re: Grading & Servicing Plan Review
Proposed Multi-Storey Building
1166 Bank Street – Ottawa, Ontario

date: July 25, 2023

file: PG6191-MEMO.02

**SITE SERVICING PLAN**

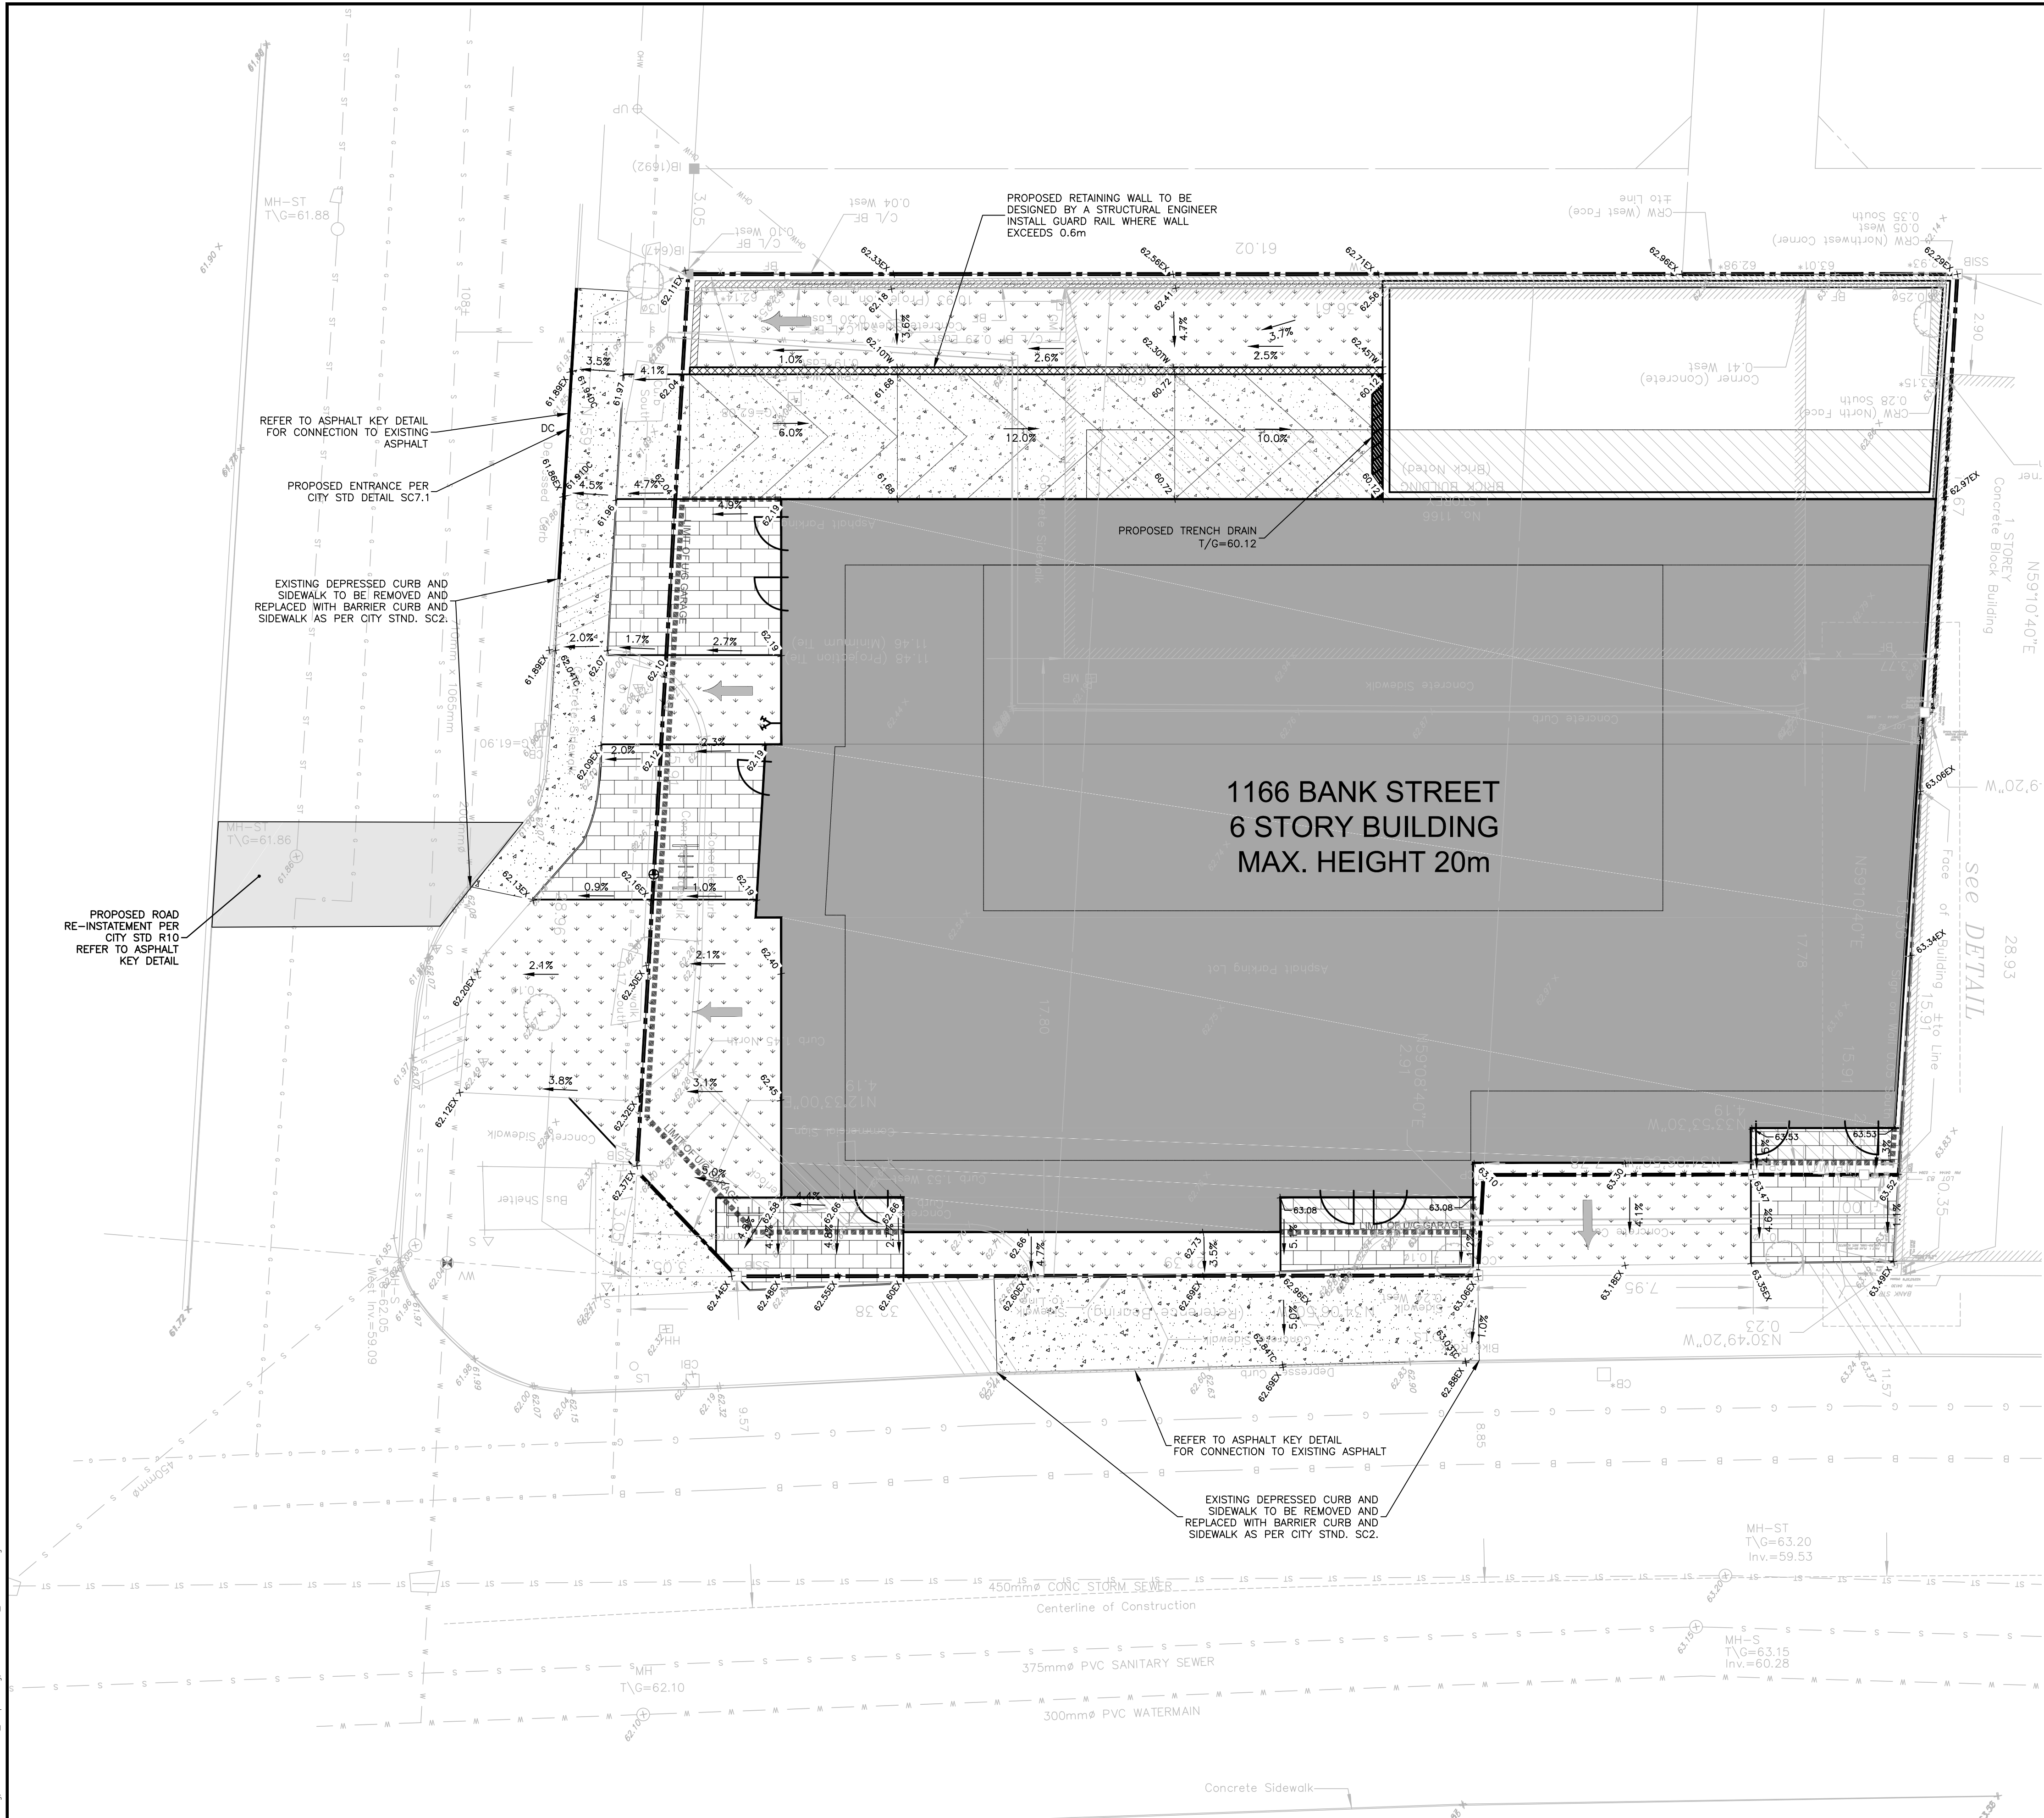
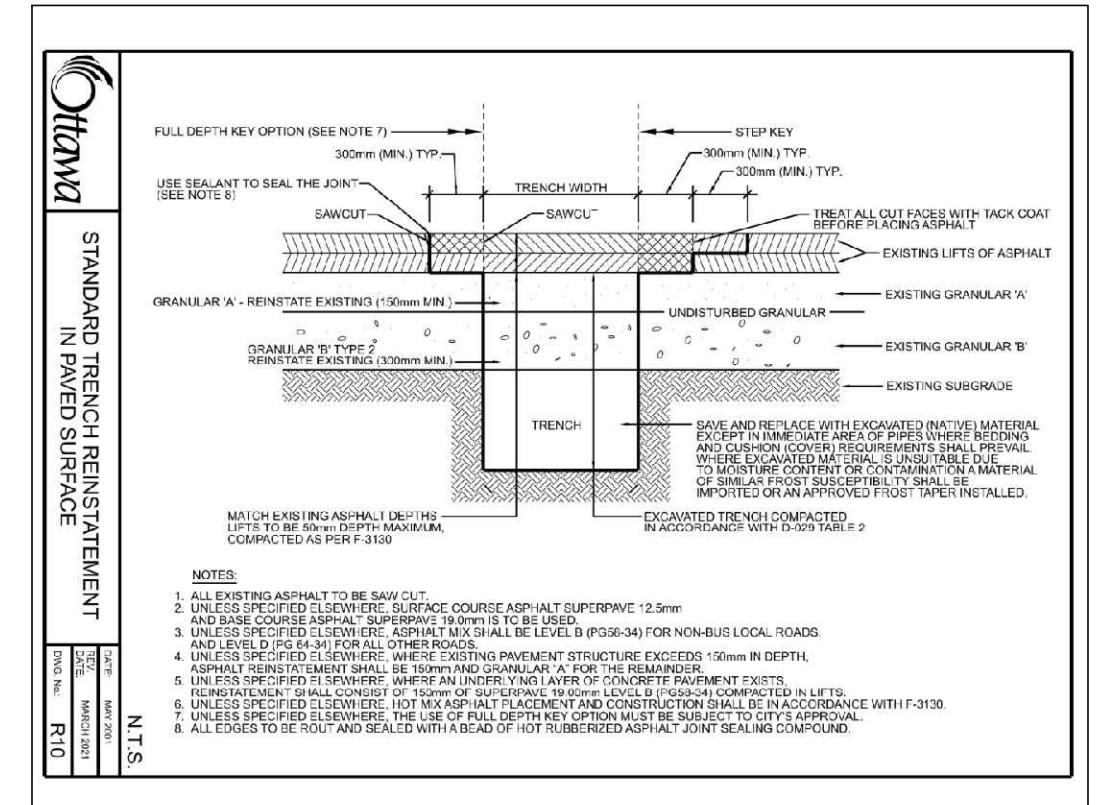
Based on our review of the site servicing plan, sufficient soil cover has been provided to the proposed watermain and sanitary services. However, insufficient soil cover was noted to be provided to the proposed stormwater service. Where insufficient soil cover (i.e. less than 2.1 m of soil cover is present above the obvert of the pipe) is available, the following frost protection criteria outlined in Table 1 should be followed. Please refer to Figure 1 – Servicing Plan Review attached which indicates the frost protection provided to each service.

Table 1 - Rigid Insulation Recommendations for Storm Sewer and Water Pipes with Reduced Soil Cover			
Thermal Condition	Soil Cover Provided (mm)	Insulation Dimensions	
		Thickness (mm)	Extension (mm)
Unheated	600 to 900	125	Extend 1200 mm horizontally beyond edge face of the pipe
	900 to 1200	100	Extend 1200 mm horizontally beyond edge face of the pipe
	1200 to 1500	75	Extend 900 mm horizontally beyond edge face of the pipe
	1500 to 1800	50	Extend 600 mm horizontally beyond edge face of the pipe
	1800 to <2100	25	Extend 300 mm horizontally beyond edge face of the pipe

All rigid insulation should consist of either Dow Chemical High-Load 40 (HI-40), Styro Rail SR.P400, or equivalent approved by Paterson. The placement of all insulation within the service trenches must be reviewed and approved by Paterson personnel at the time of construction.

**SITE GRADING PLAN**

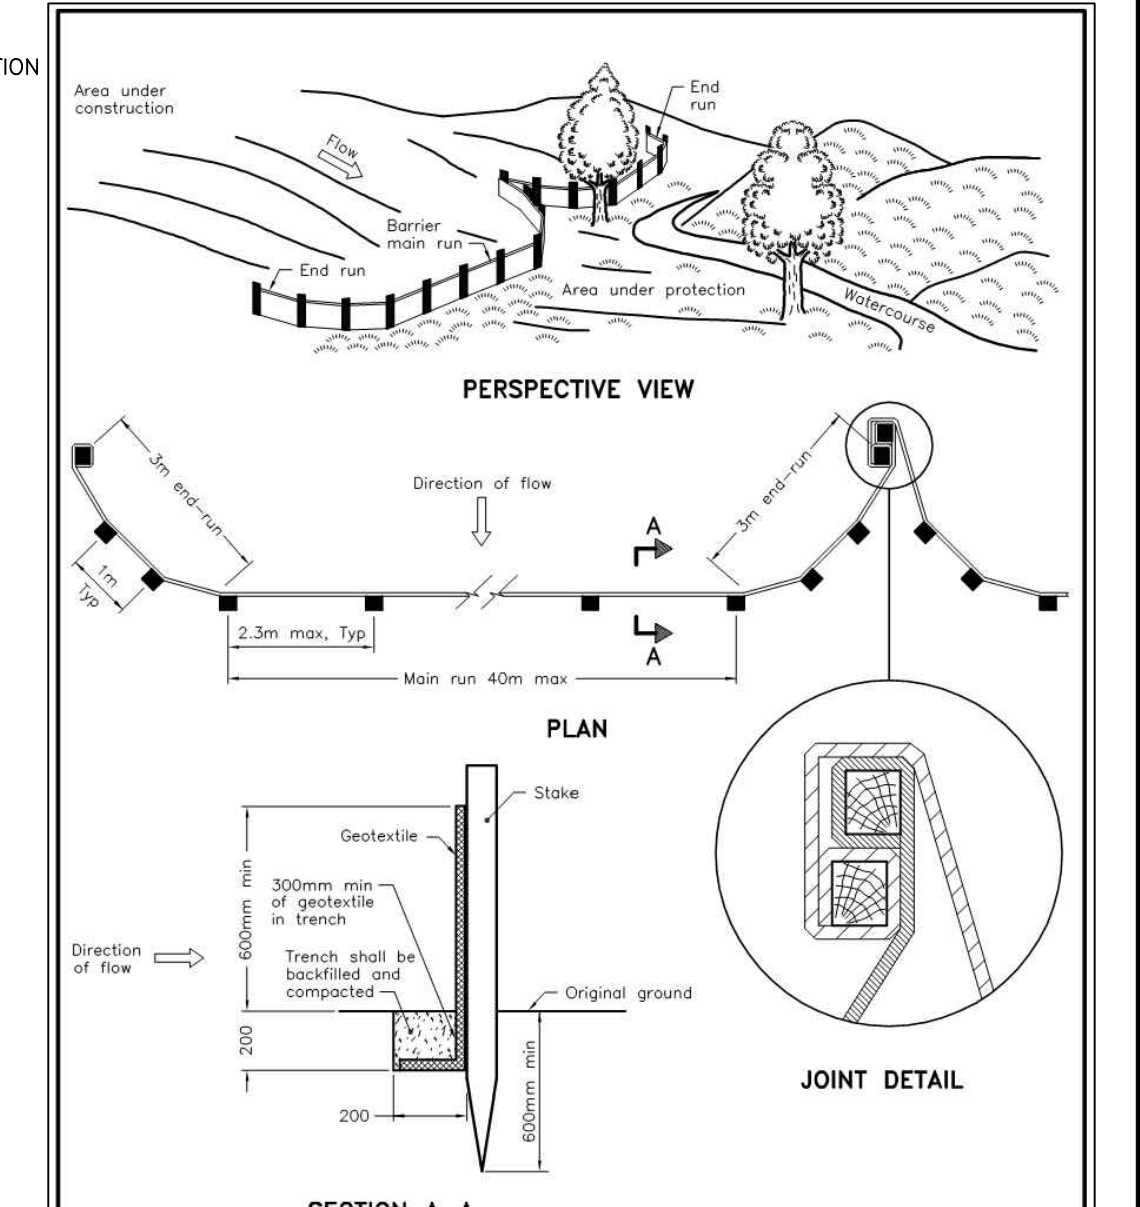
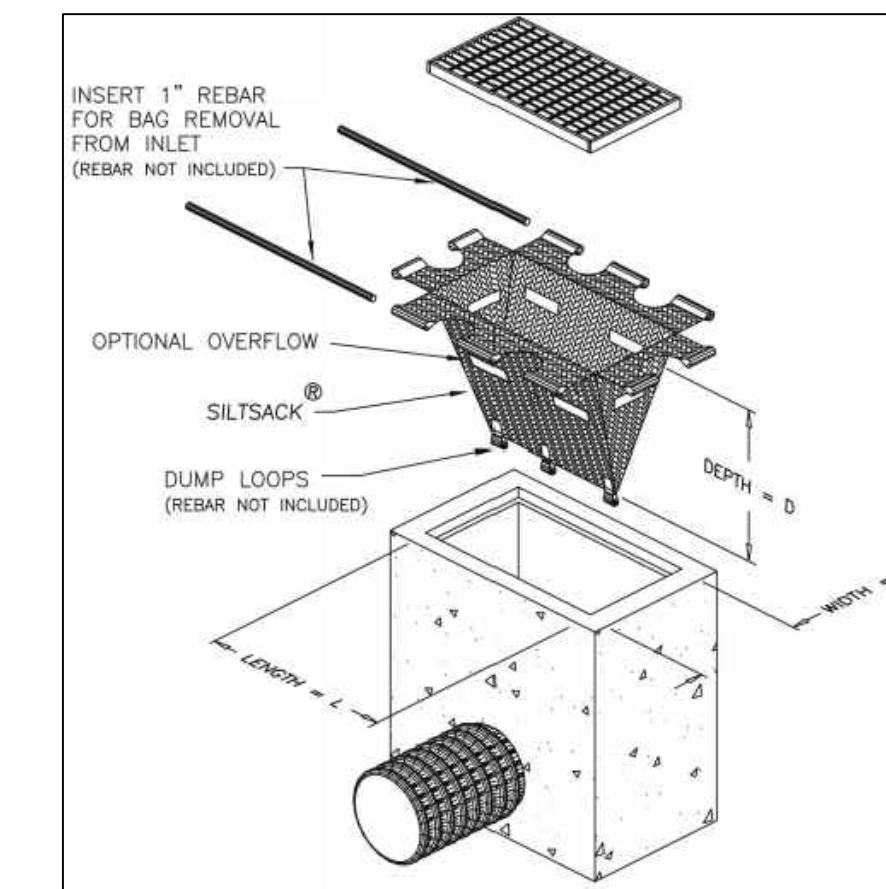
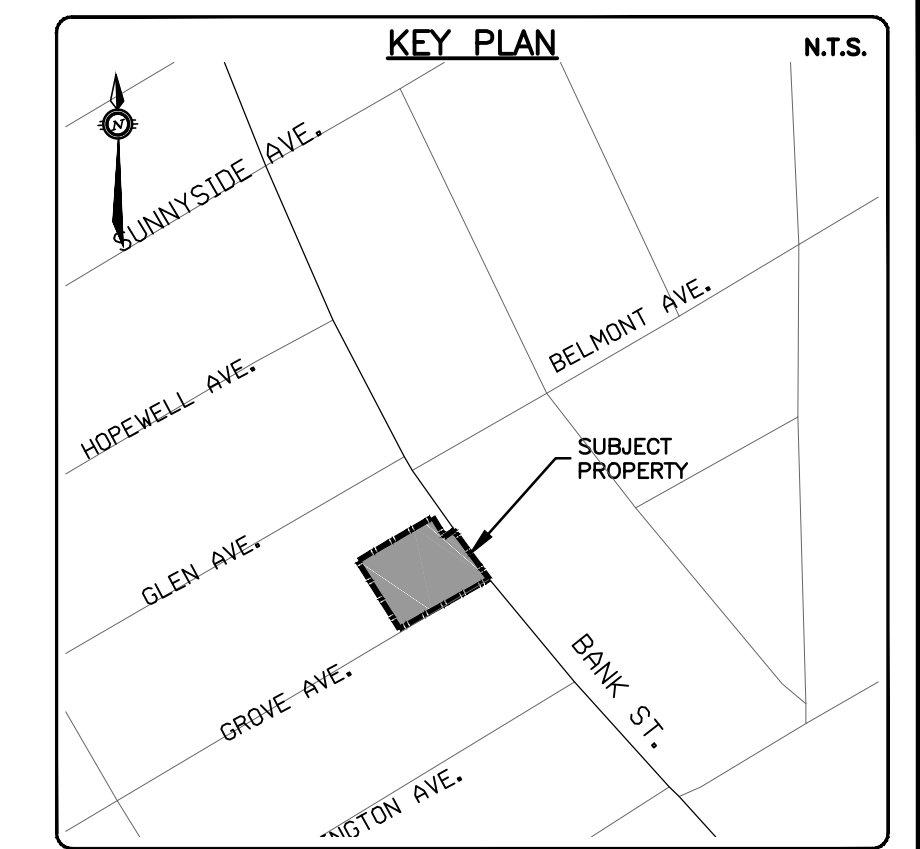
Based on our review of the above-noted grading plan drawing, the proposed grade raises at the subject site are within the recommended permissible grade raise of 1.0 m. Therefore, the proposed grading is acceptable, from a geotechnical perspective.
